SCOPE/BACKGROUND

We inspected the repairs of the subject building on May 1, 2025. The purpose of the inspection was to determine if the crawlspace repairs (wood repair, pier installations) were installed per recommendations outlined in the previous inspection report dated June 6, 2024. The following itemizes our review of the repairs:

STRUCTURAL SUPPLEMENTAL PLAN - 40 PSF

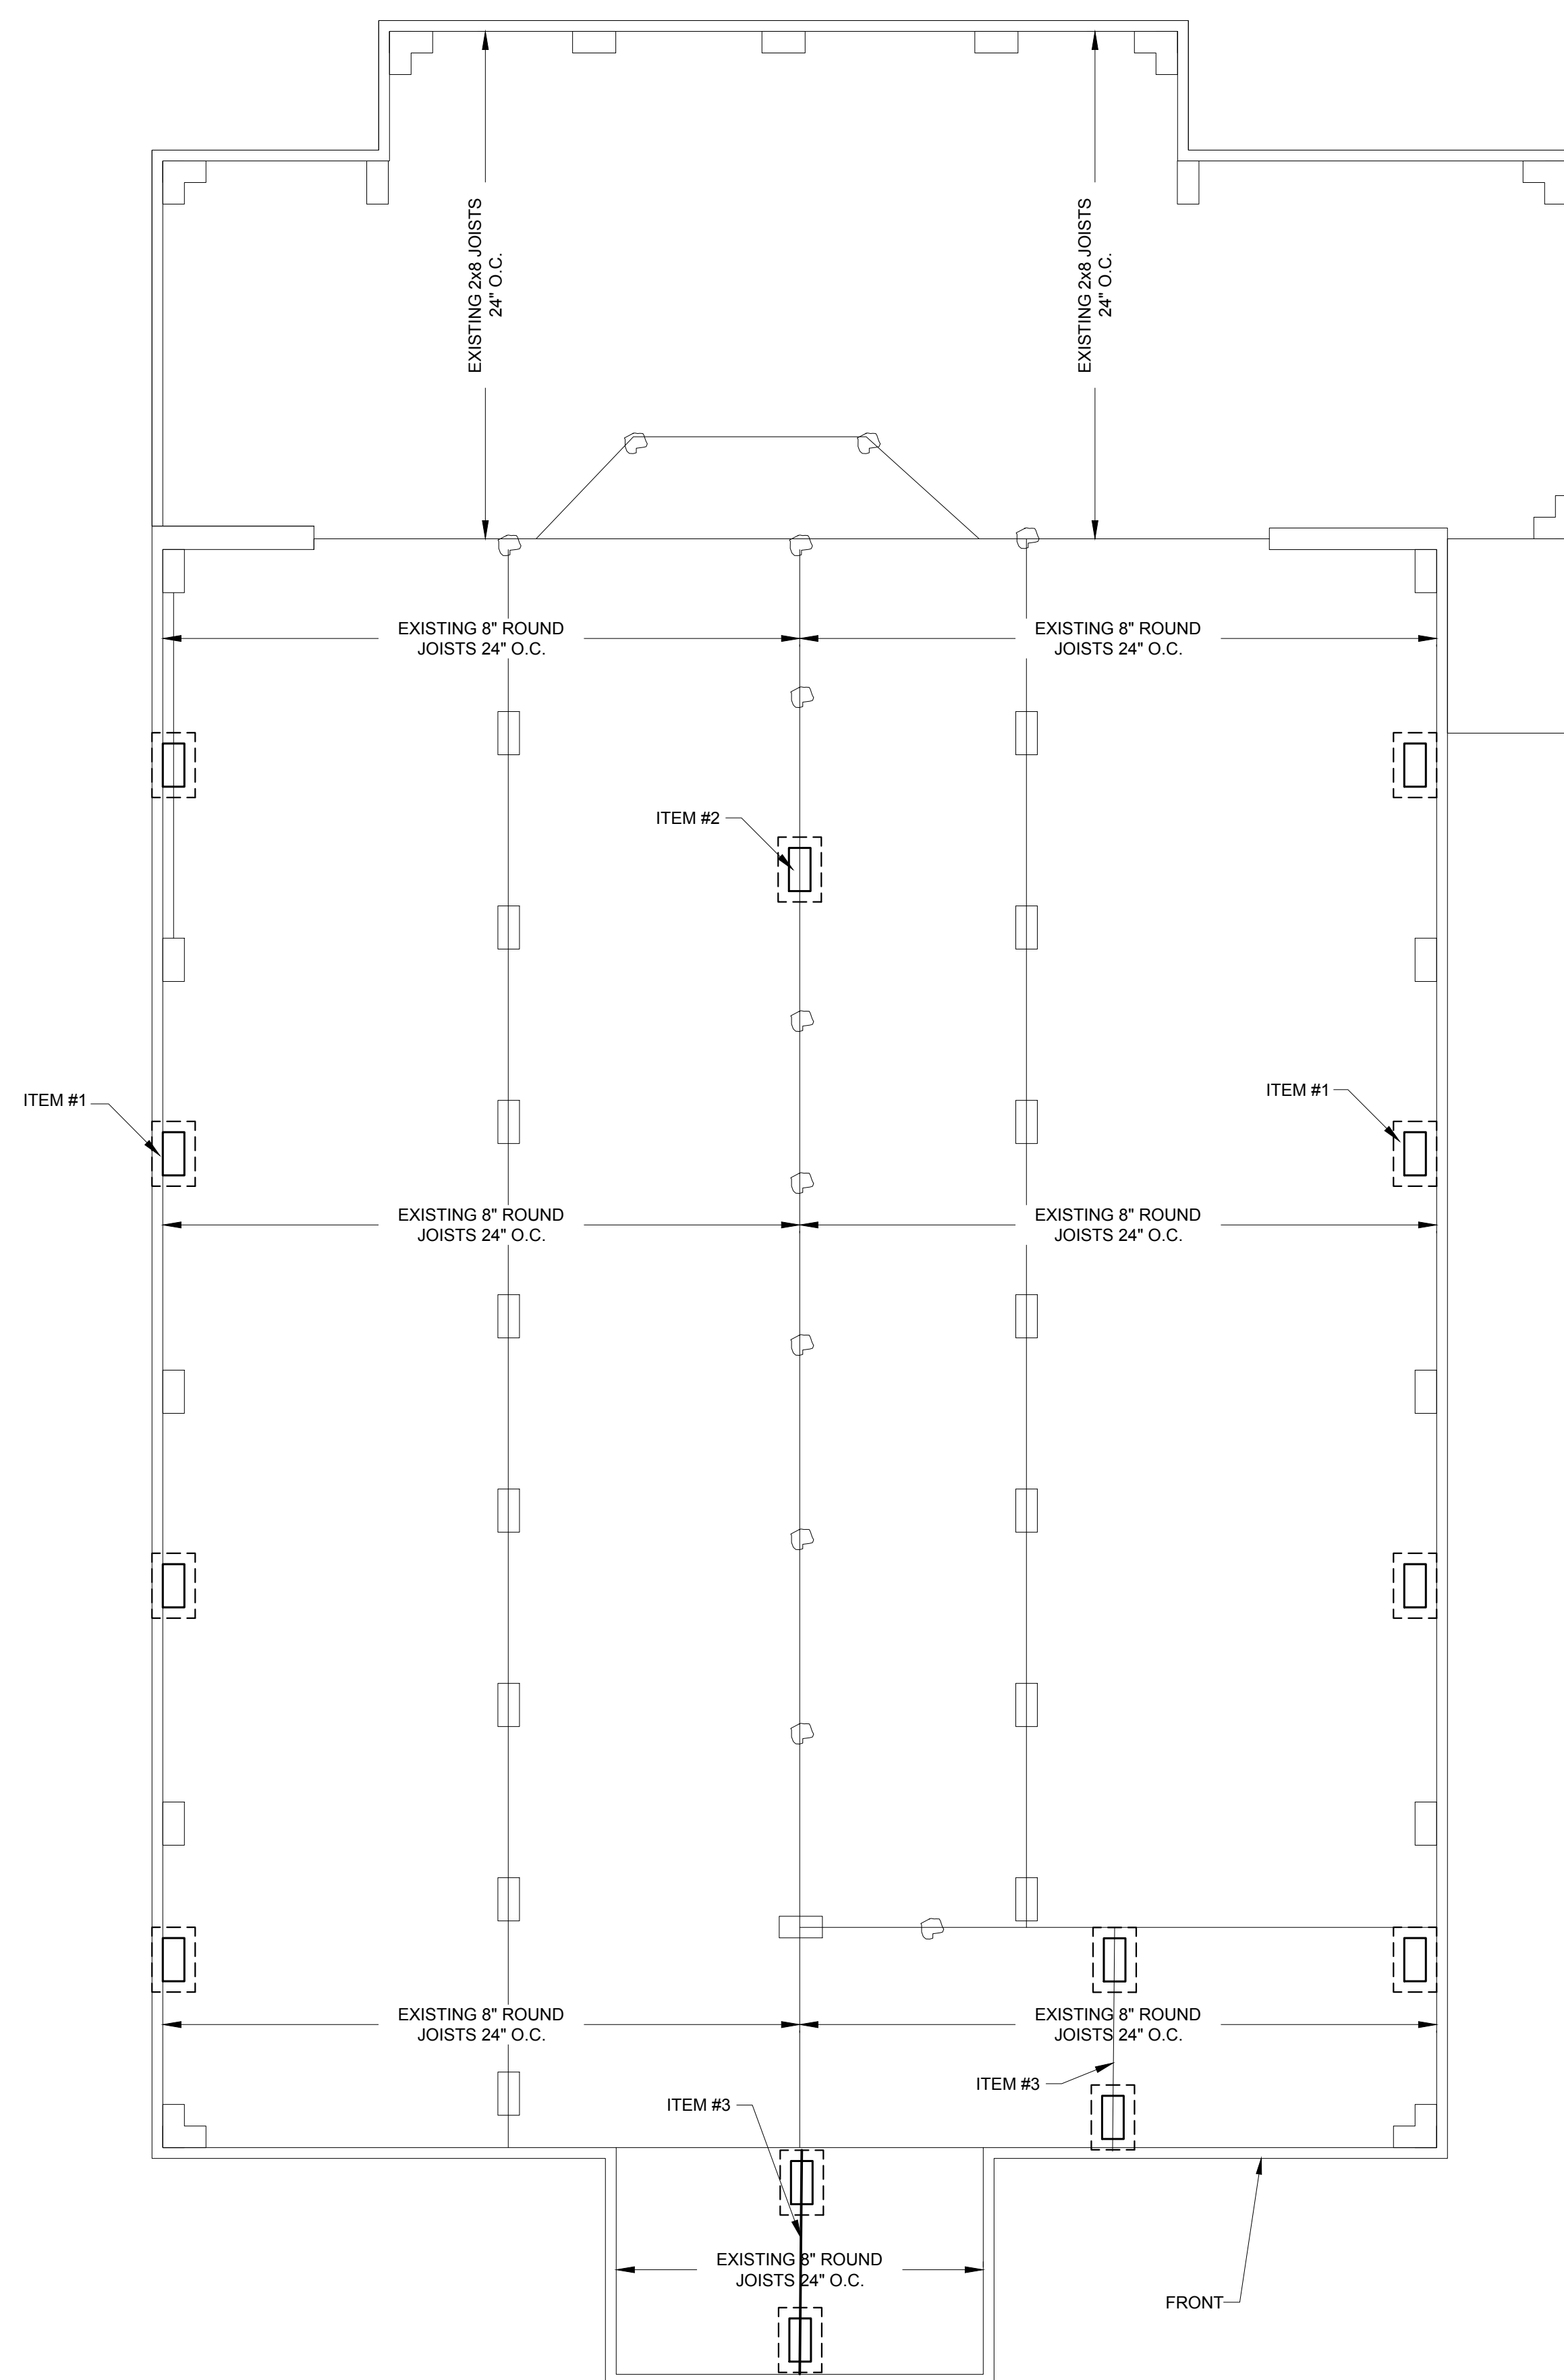
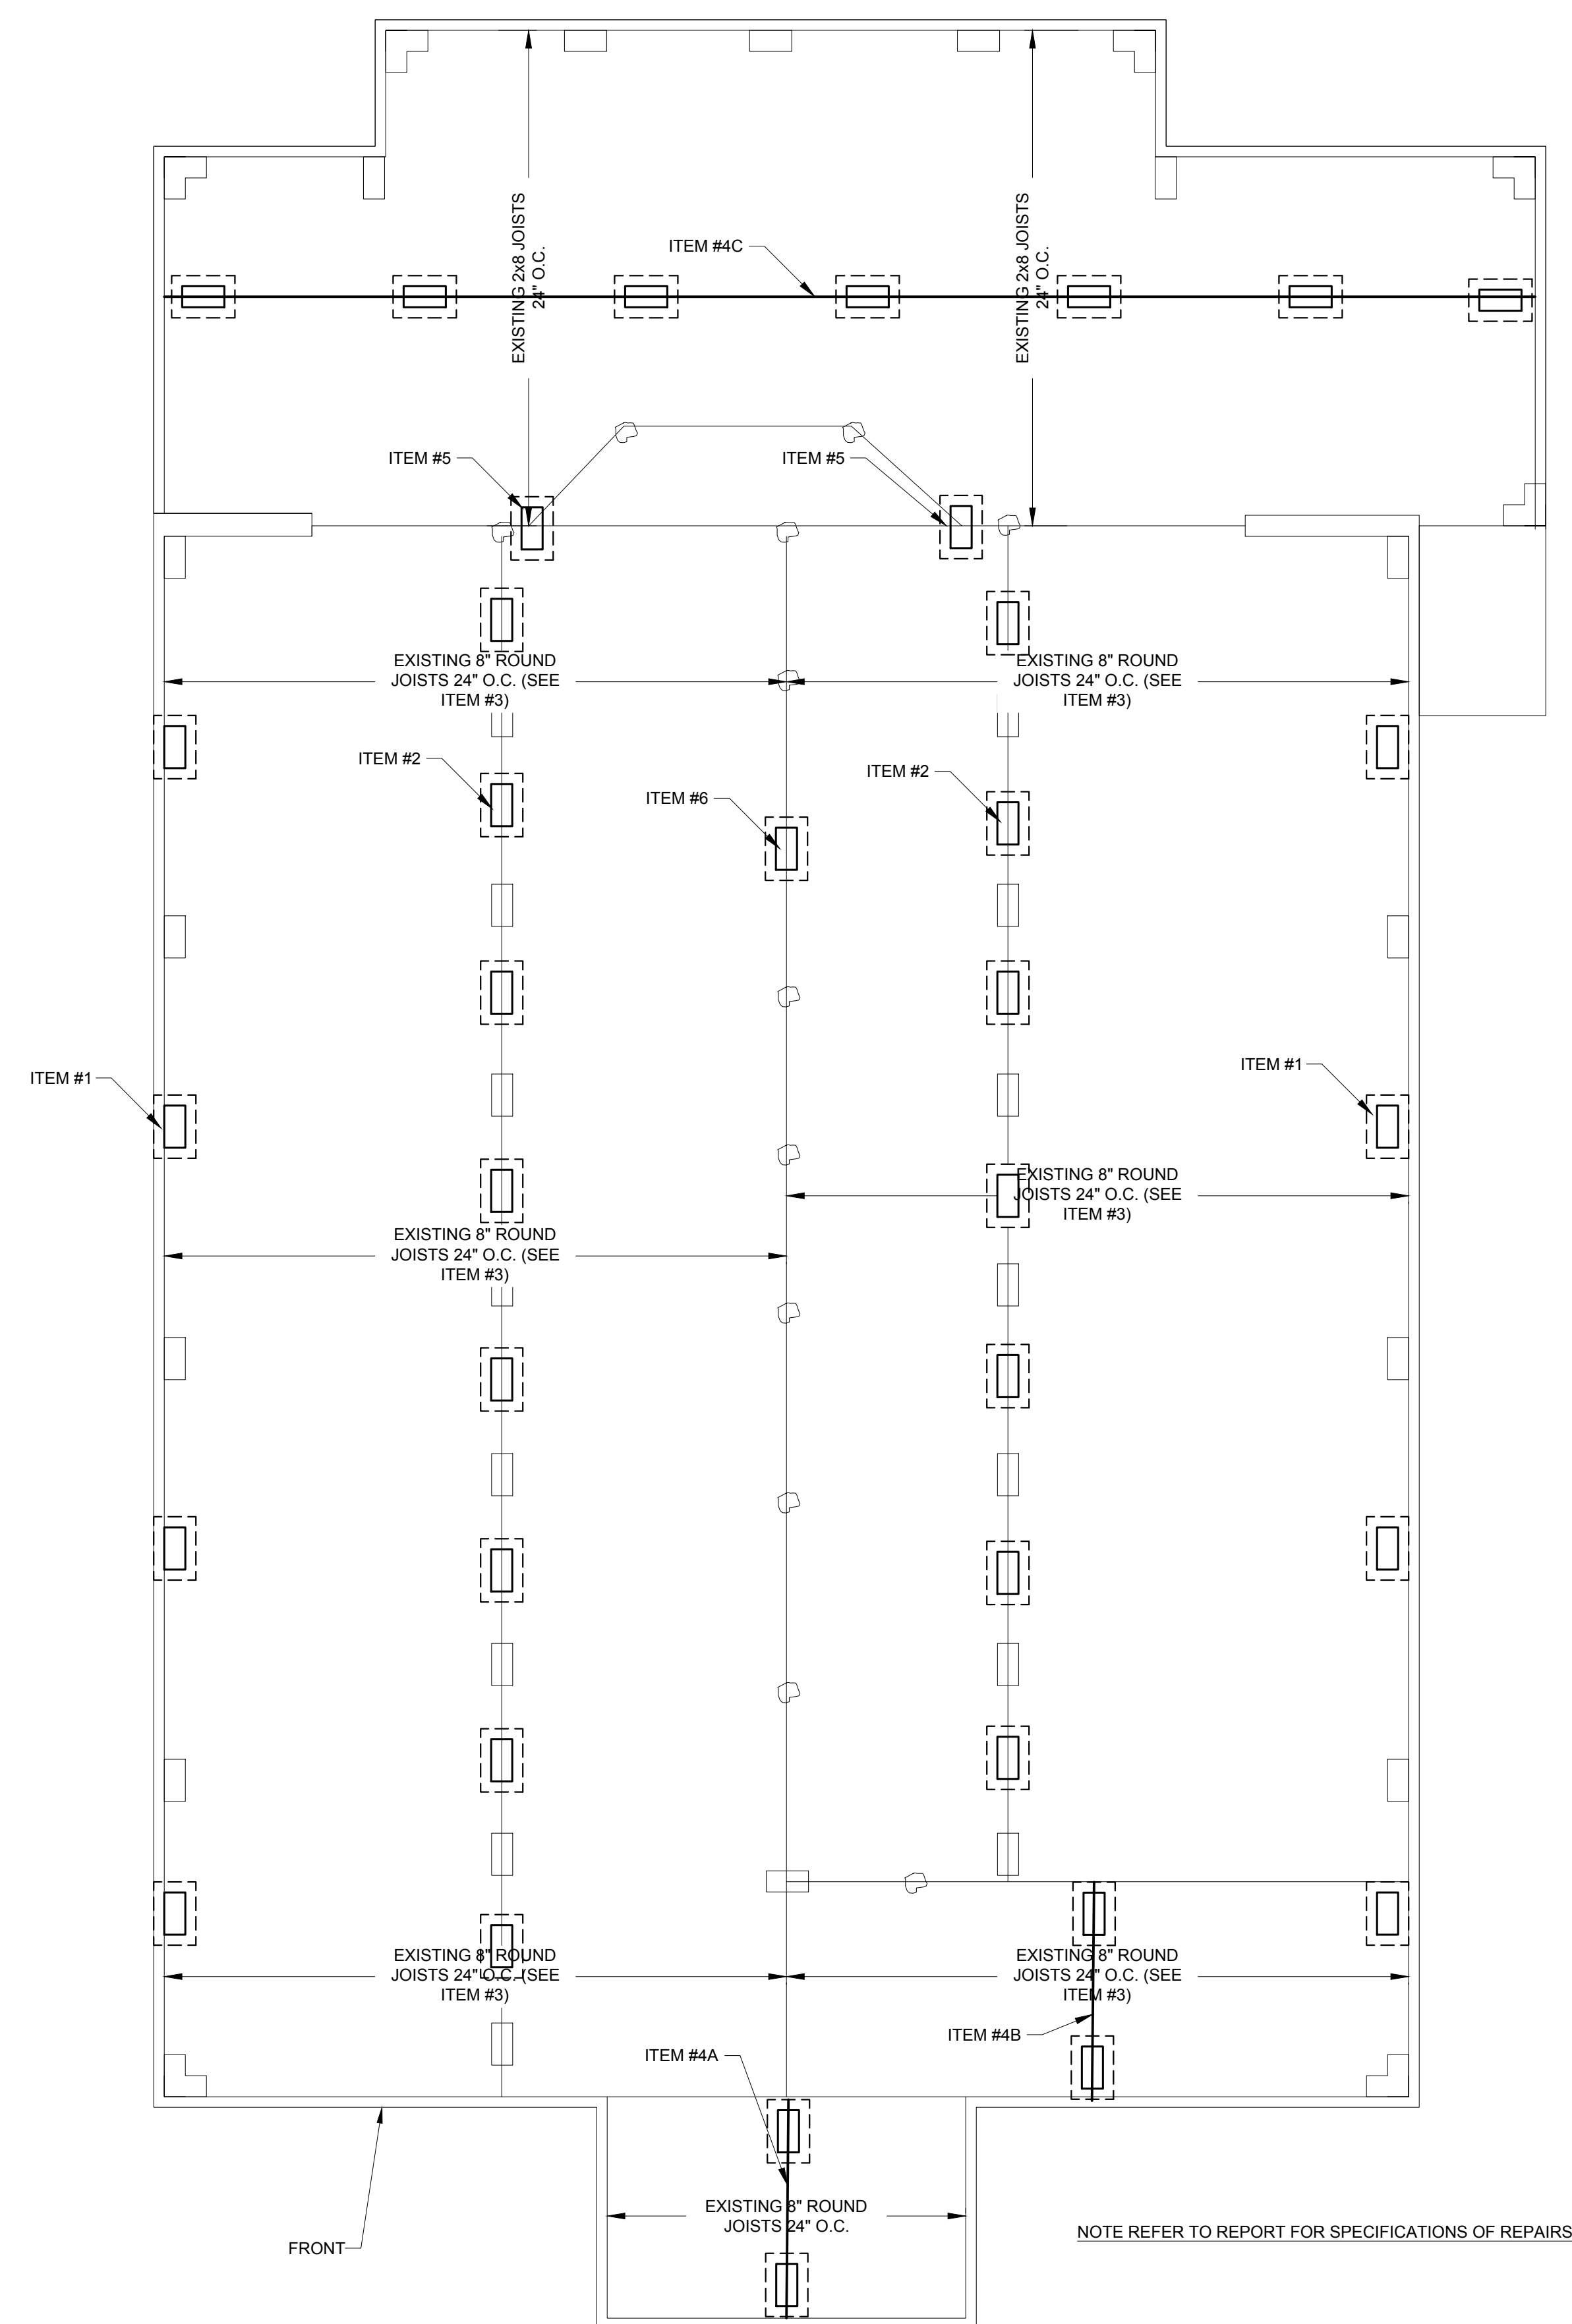
2. The drop girders on each side of the original central girder had been replaced with 4-2x8 girders.
3. The girders in the rear classroom section had been fully sistered per the plans.

4. Additional piers had been added per the locations on the plans. Per our guidance, additional piers were installed at the front-right and front-left corners. The damaged masonry piers appeared to have been replaced, while some of the stone piers remained in place.
